WELWYN HATFIELD ACCESS GROUP
 the common room
 ground floor
 ley house
 long ley
 welwyn garden city
 hertfordshire al7 2ex

7 August 2014

re: Planning Applications Received by Welwyn Hatfield Council

Application No.	Description and Location	Applicant/Agent
N6/2014/1503/FP	Change of use from Sui-Generis to B2 (general industrial). 29 Burrowfield Welwyn Garden City AL7 4SS	Mr S Griffiths South Mimms Travel Limited 29 Burrowfield Welwyn Garden City AL7 4SS

Drawing No 2 : MGE02072014

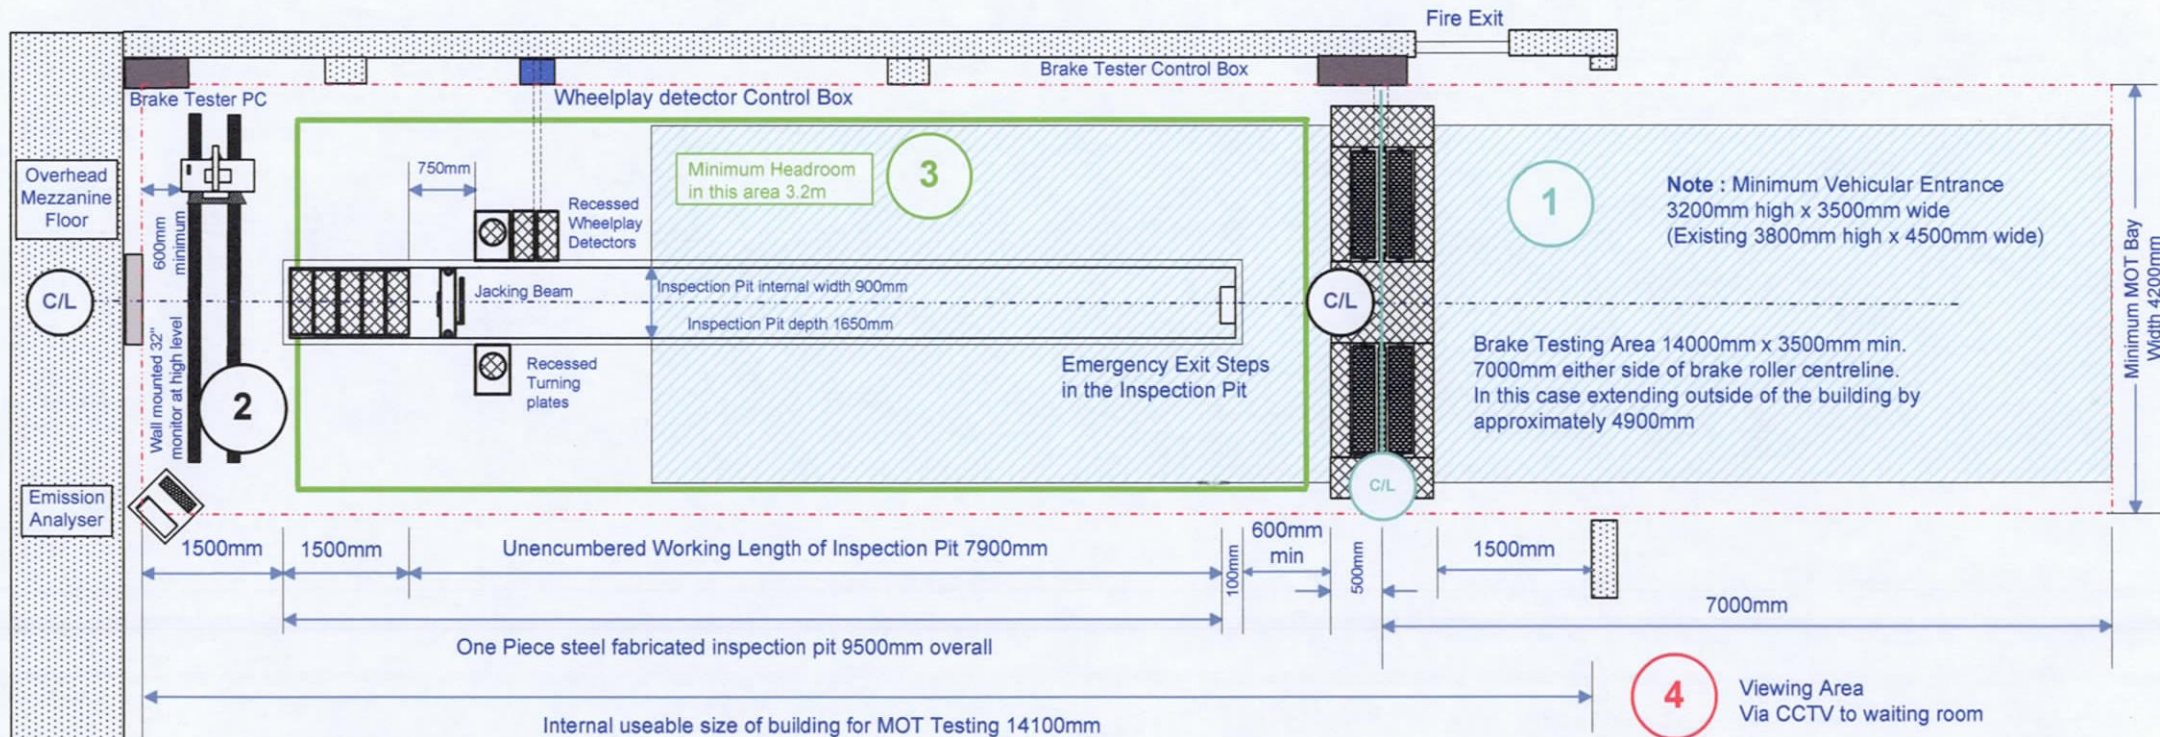
This drawing makes reference to 'Viewing Area via CCTV to waiting room'. Unfortunately, we are unable to identify from the drawing where the waiting room is located. Furthermore, we are unable to determine if a customer toilet is provided

Could you kindly provide answers to both these questions?
